**RE: PA22-044 – Olympic Vista PRD – Technical Review 1**

Please refer to our responses below which address all review comments received from the City of Marysville on February 28th, 2023, regarding the Olympic Vista PRD application package. You will find the markup comments listed in the order that they were written followed by our response in *italics*.

KEYSTONE LAND, LLC.
OLYMPIC VISTA PRD
 ROAD, STORM DRAINAGE AND GRADING PLAN

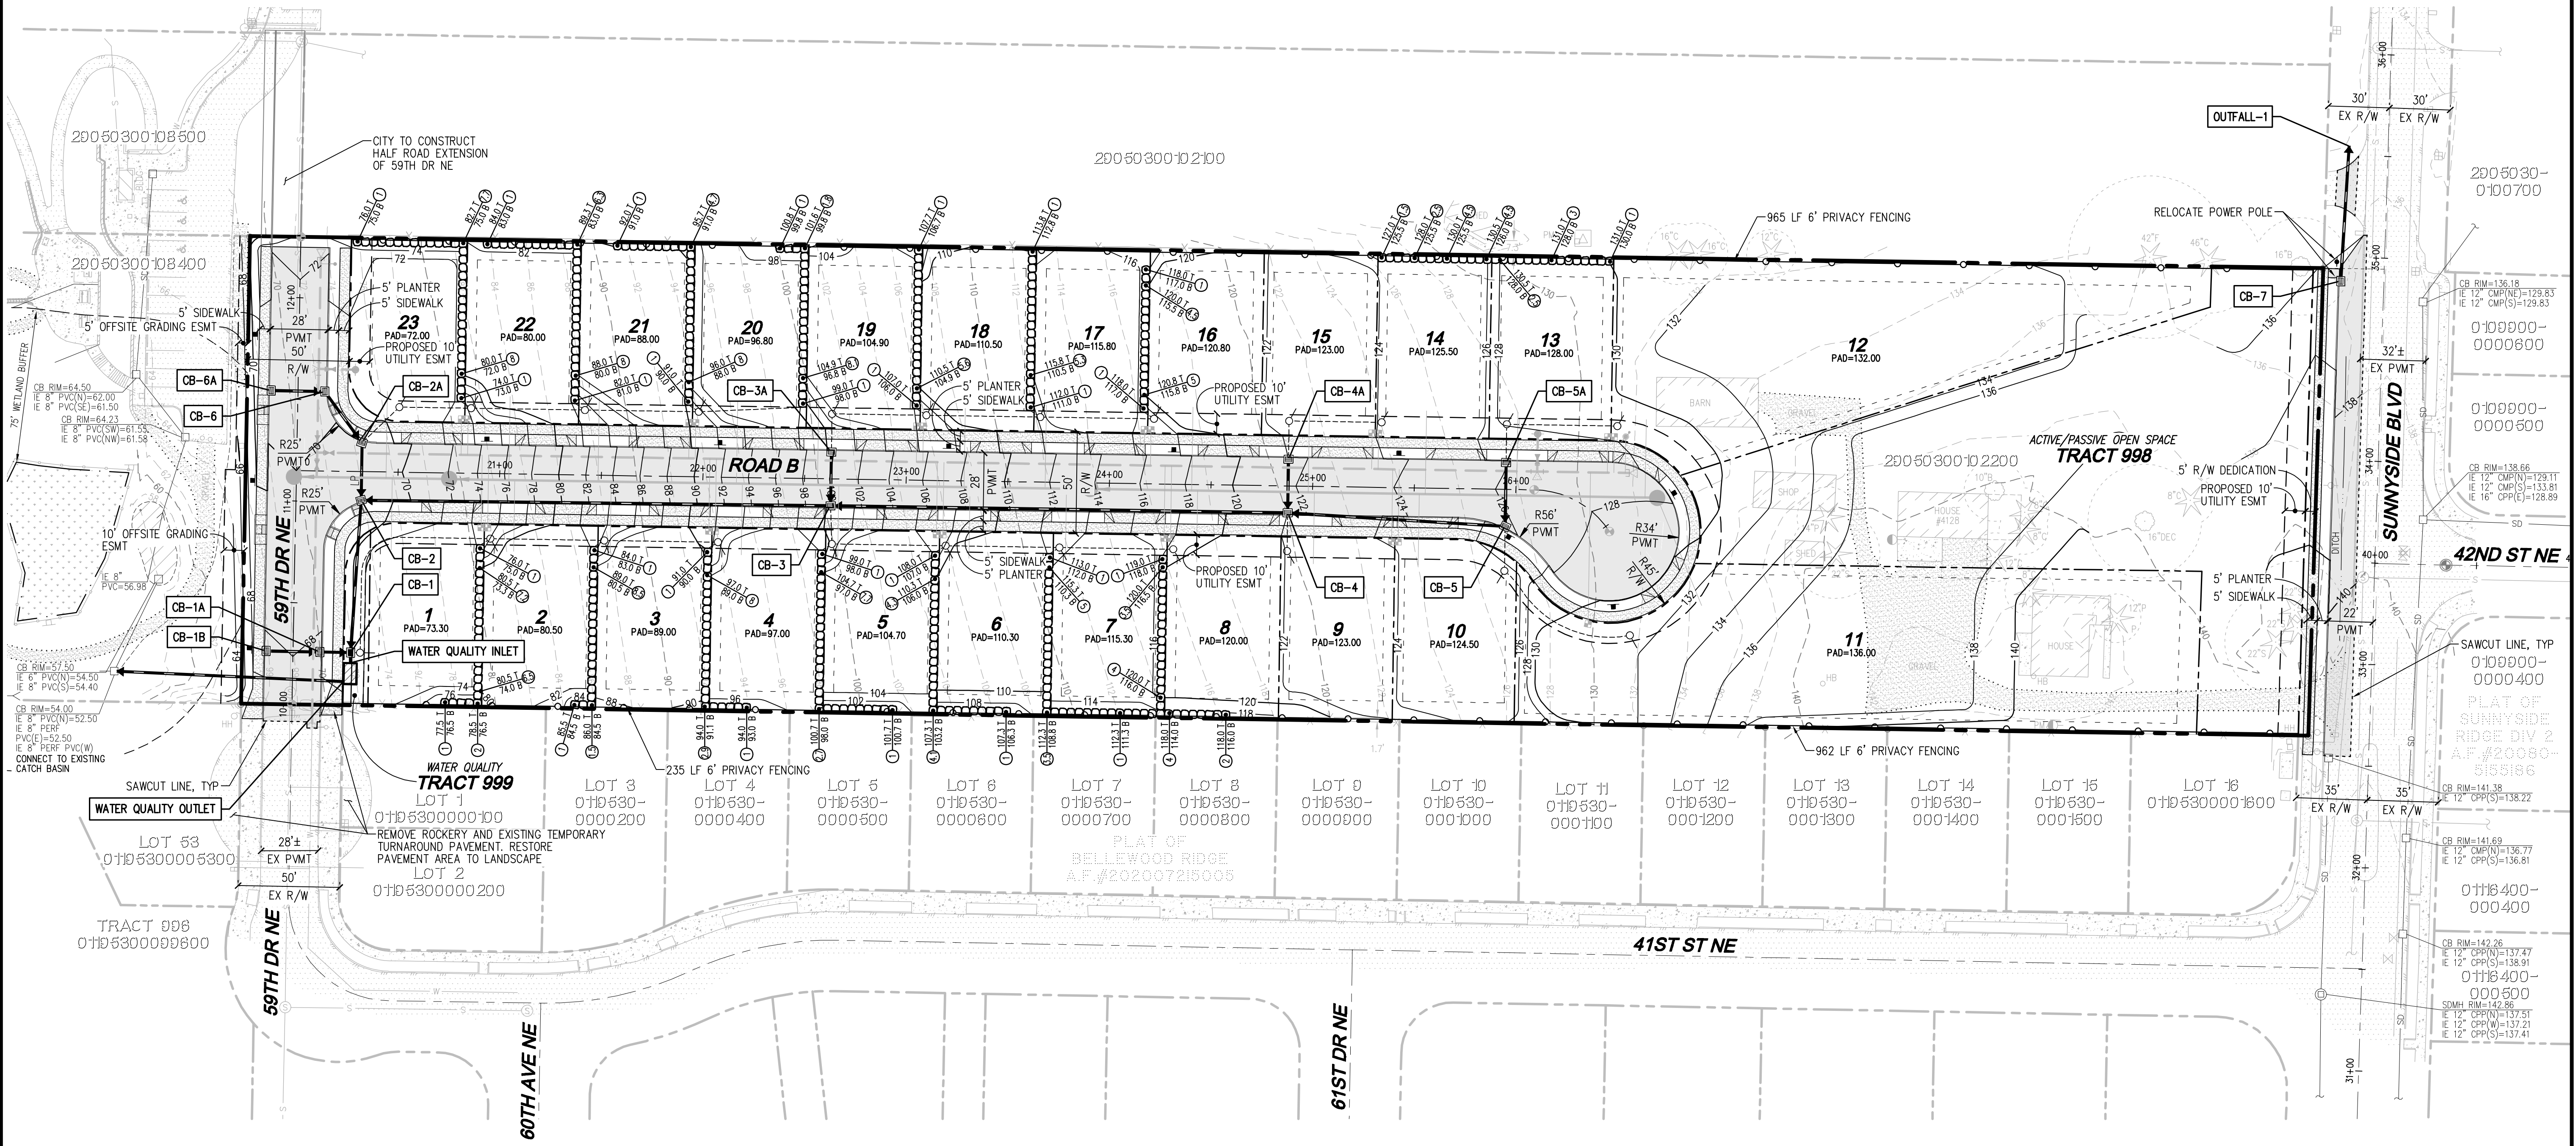
1. All projects in the city of Marysville must comply with requirements stipulated under the MMC 14.15.040 and 14.15.050.
  - a. Stormwater drainage: There was in depth discussion about the proposed outfall connection and it doesn't appear that any of that is included in this submittal. Please provide details about your proposed outfall system and any changes proposed for what is

4. On the civil plans please show the offsite conveyance improvements that will be made downstream in Olympic View Park.

***Response: The outfall has been included in the revised plans and discussion and calculations have been provided in the drainage report.***

**Response: The civil plans have been revised to include the offsite conveyance downstream of the site and Olympic View Park.**

SHEET  
**L-1**  
 OF 3

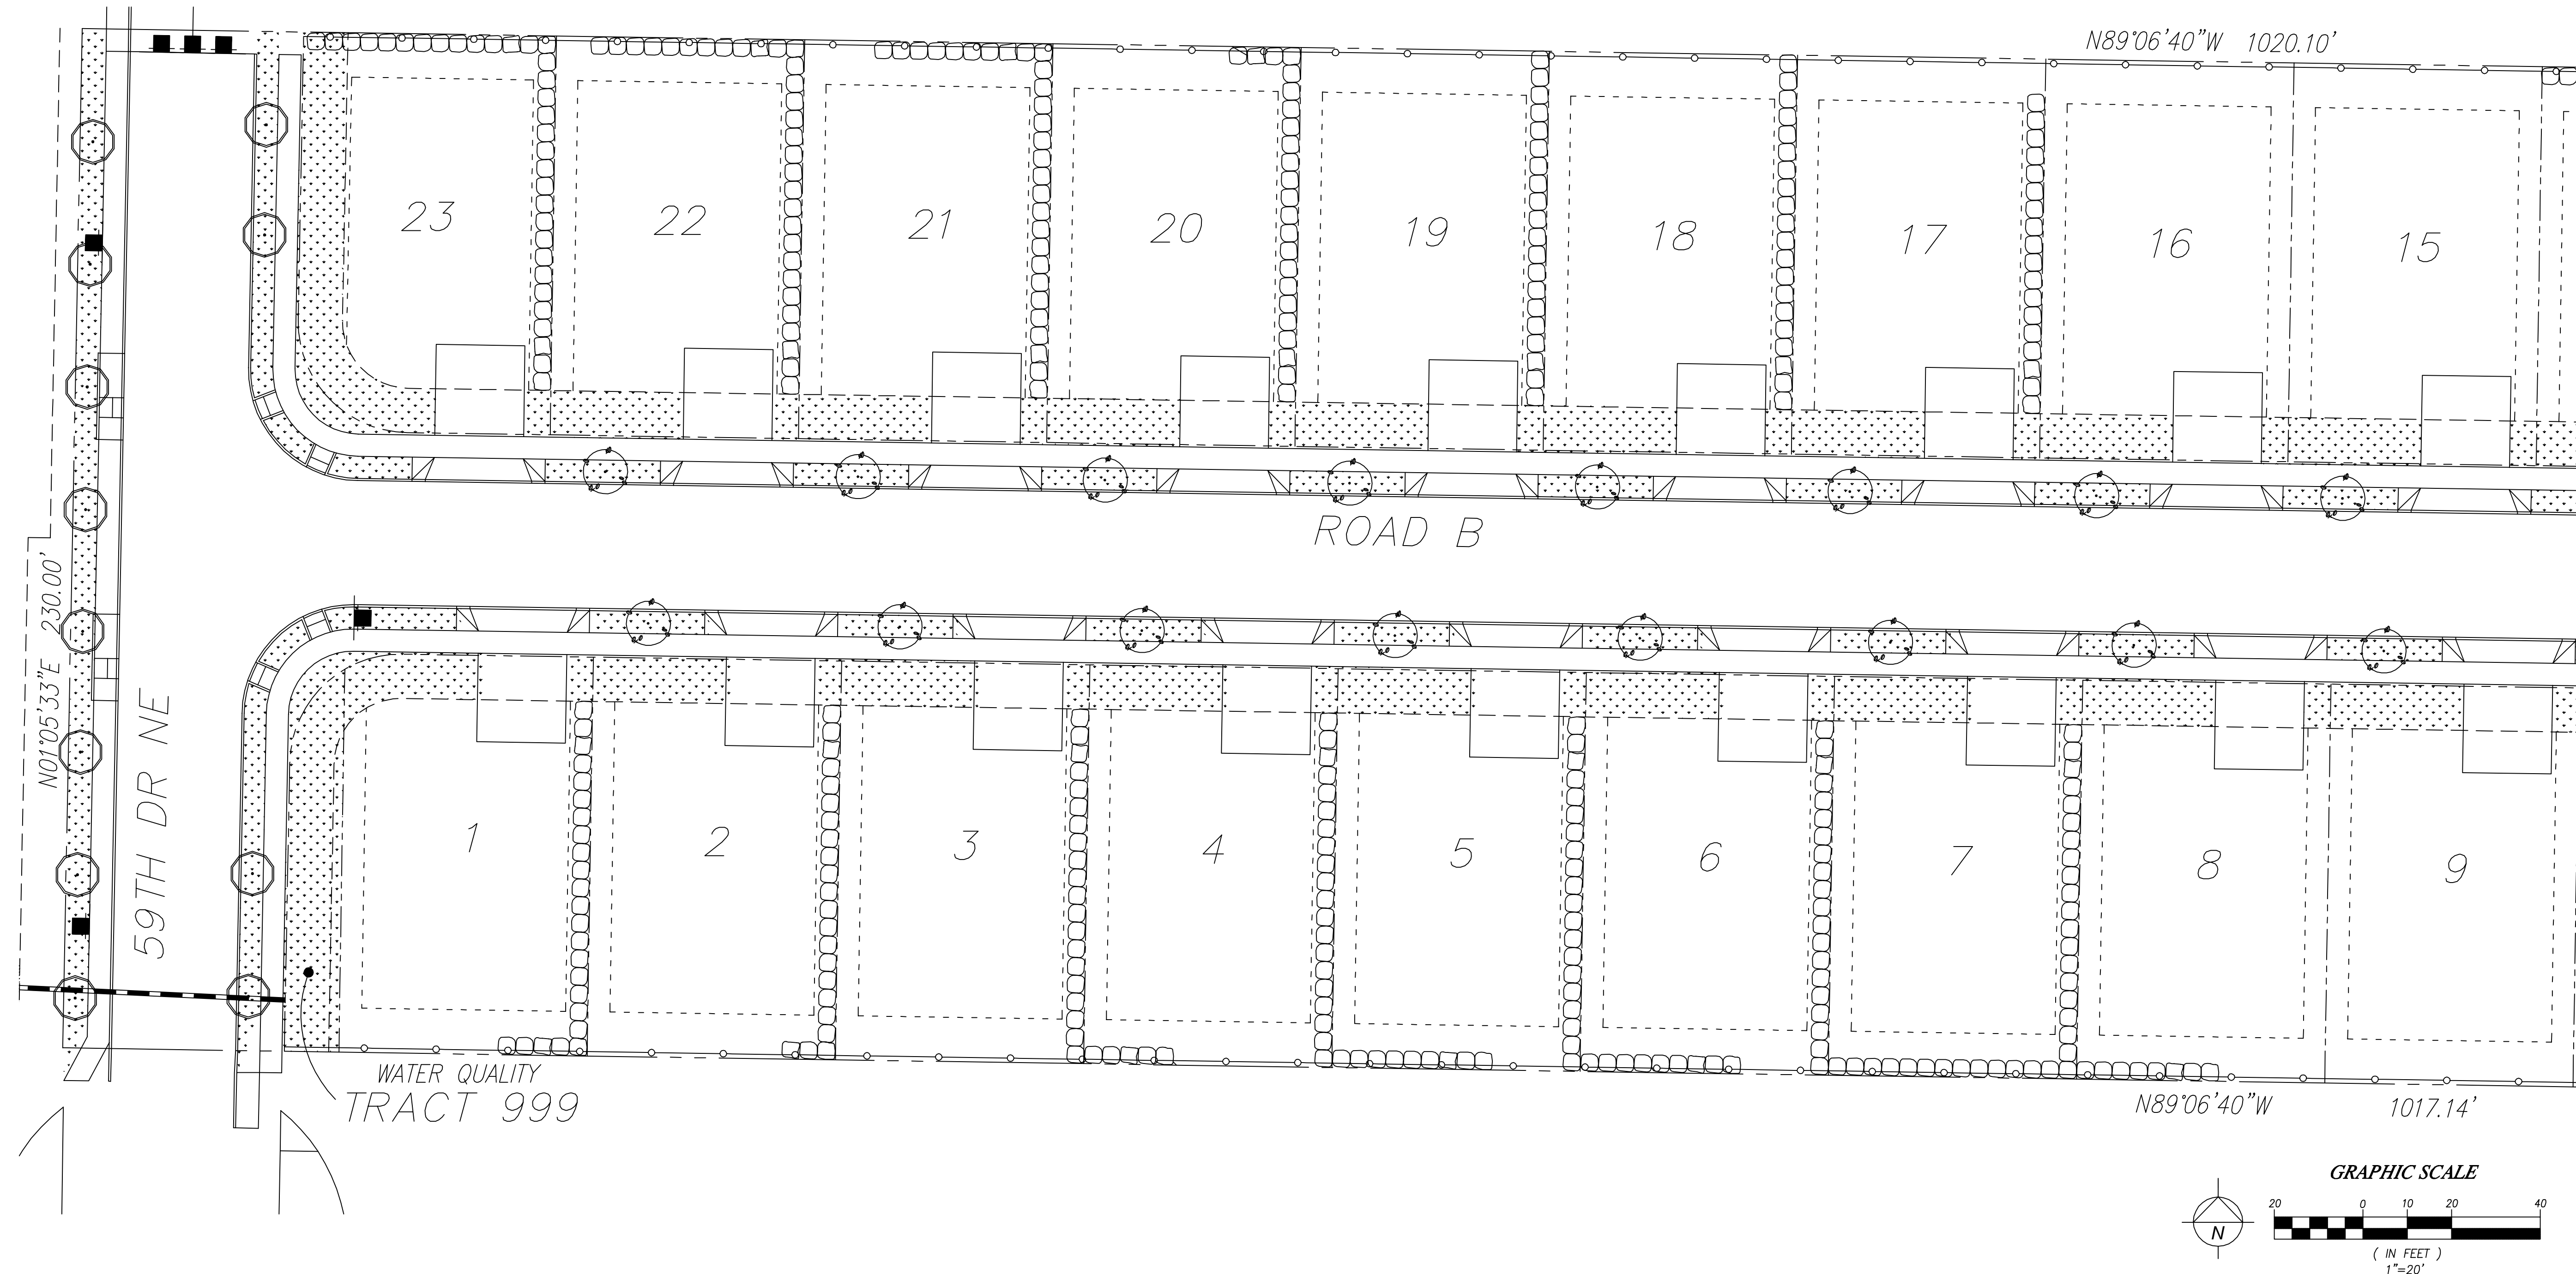
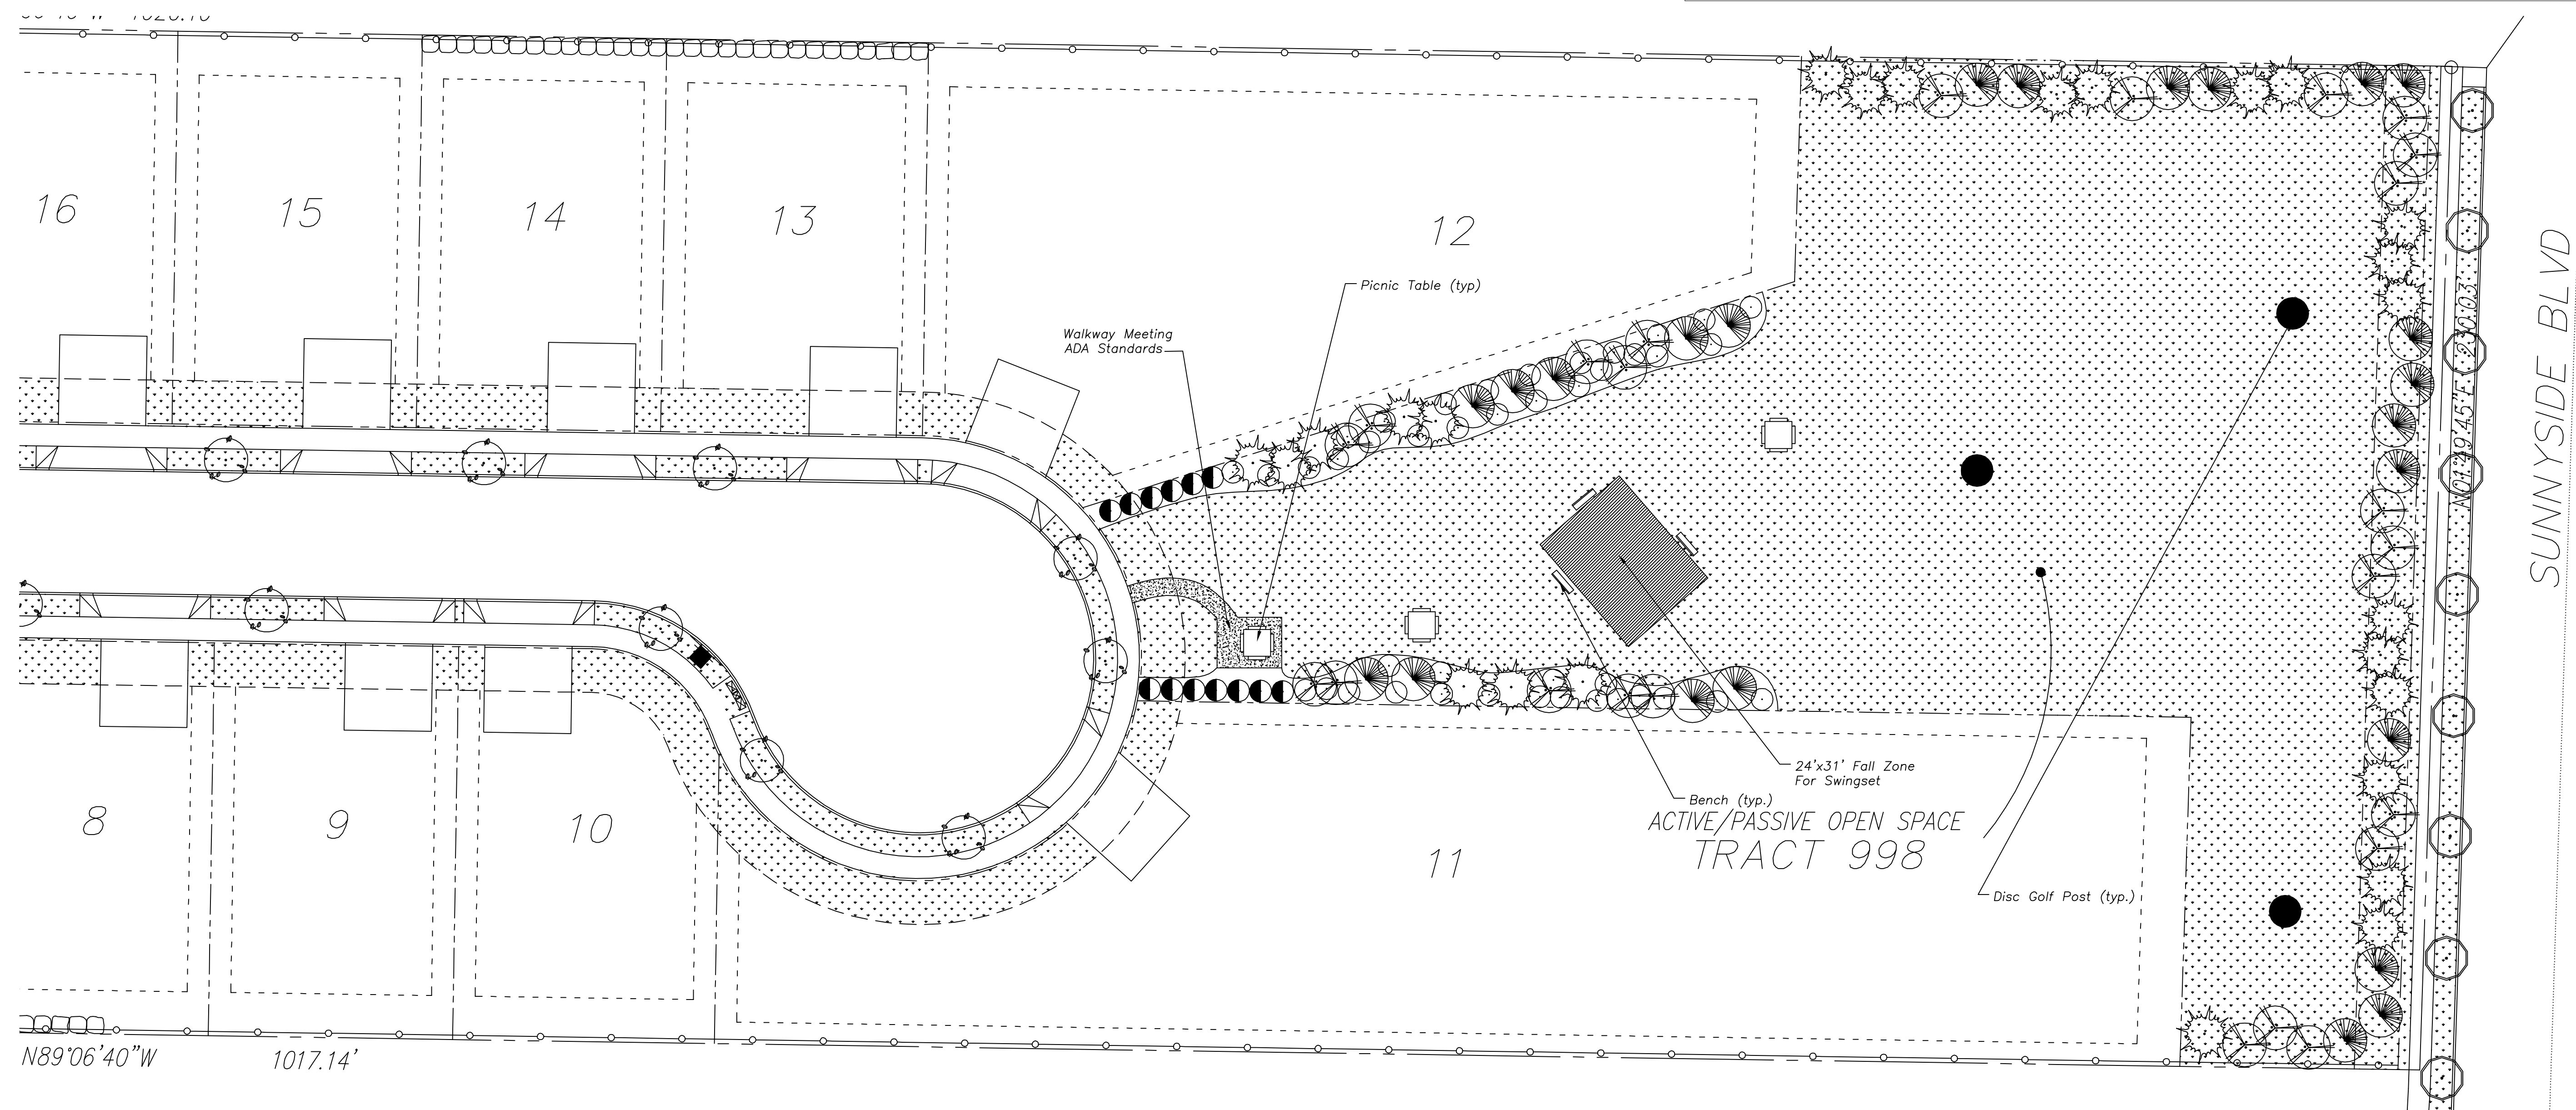
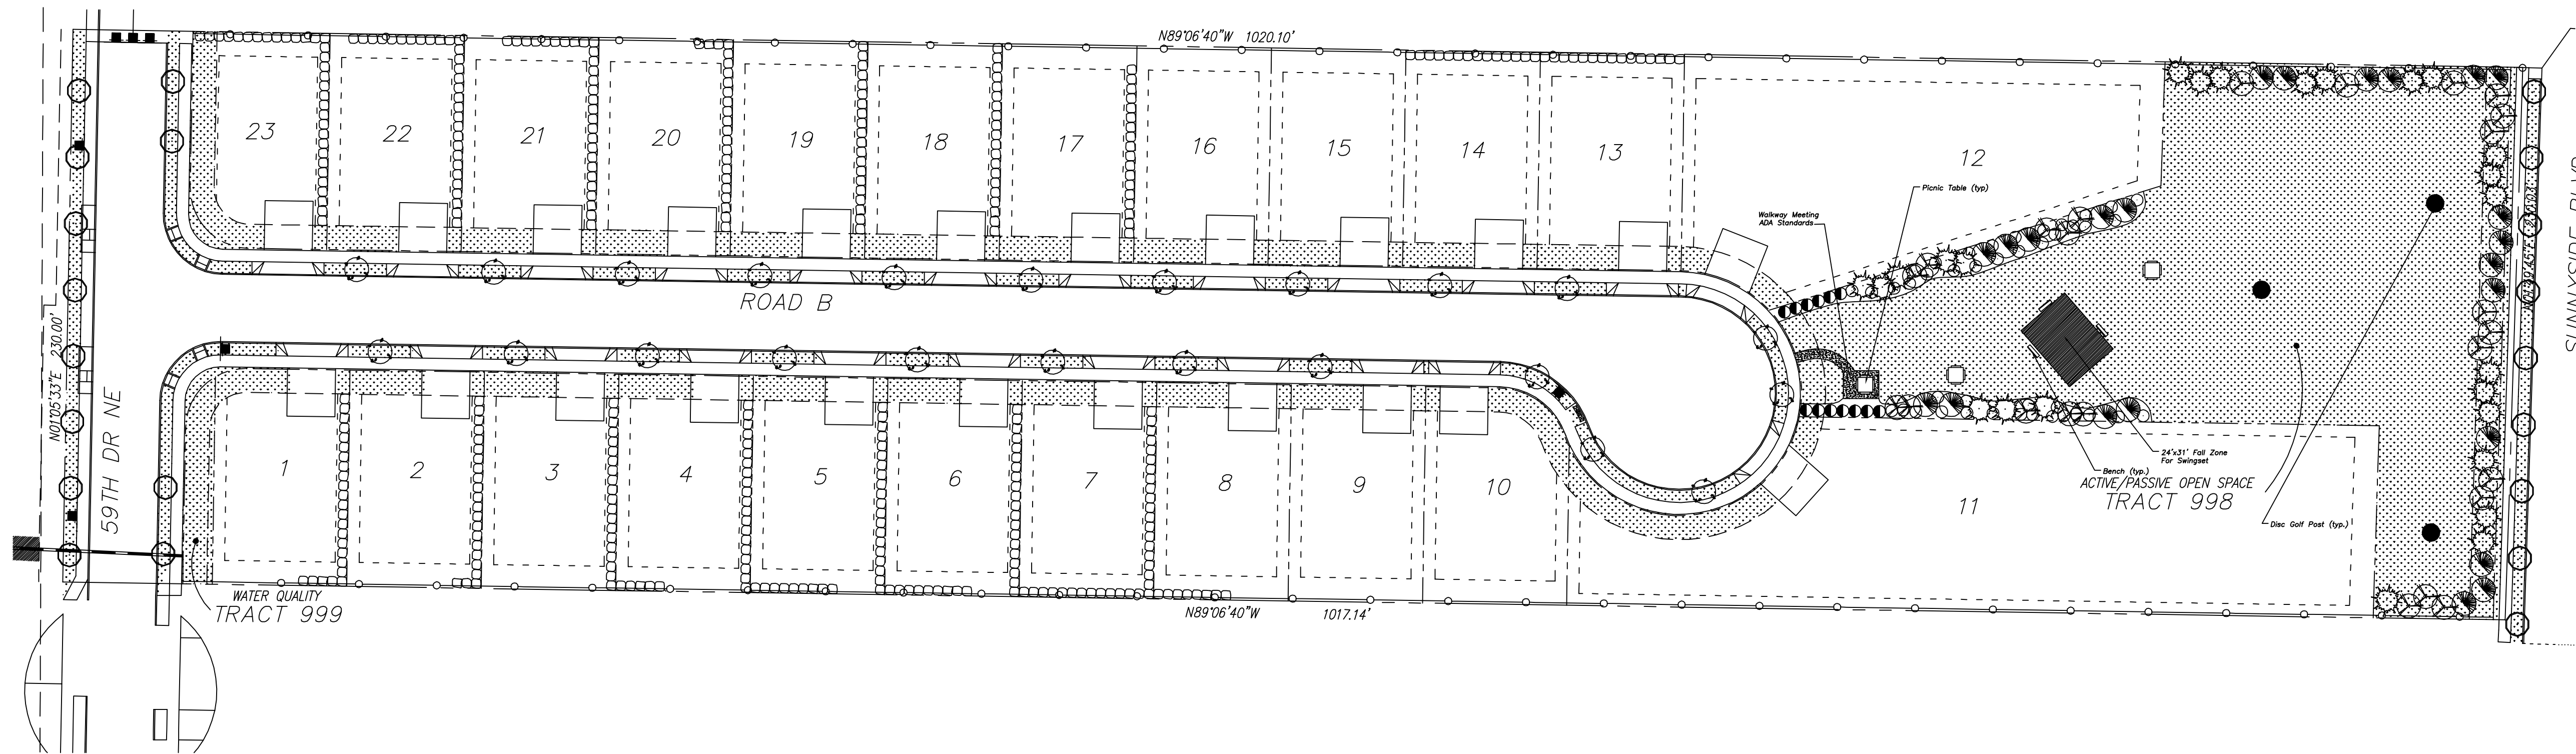
11. Sheets 9-11 (L-1, L-2, and L-3) of the Preliminary Civil Plans are not consistent with the proposed layout of the project. Please revise to be consistent with the current proposed layout.

12. A final landscape plan shall be required to be approved, prior to civil construction plan approval, and designed to comply with the applicable provisions outlined in MMC Chapter 22C.120, Landscaping and Screening. Specifically, please revise the Landscaping Plan to include:

- 12.1 Provide details of the plantings in Tract 999. Is the intent for it to be all turf? Does this provide the required water quality treatment?
- 12.2 Street trees on 59<sup>th</sup> Drive NE should be the same species as those planted in the subdivision to the south.
- 12.3 The Parks Maintenance Supervisor has suggested using a powder coated playset to ensure that it can be easily cleaned and maintained.

**Response: The landscape plans have been updated to match the civil plans.**

**Response: Please see the revised landscape plans for updated details related to these comments above.**
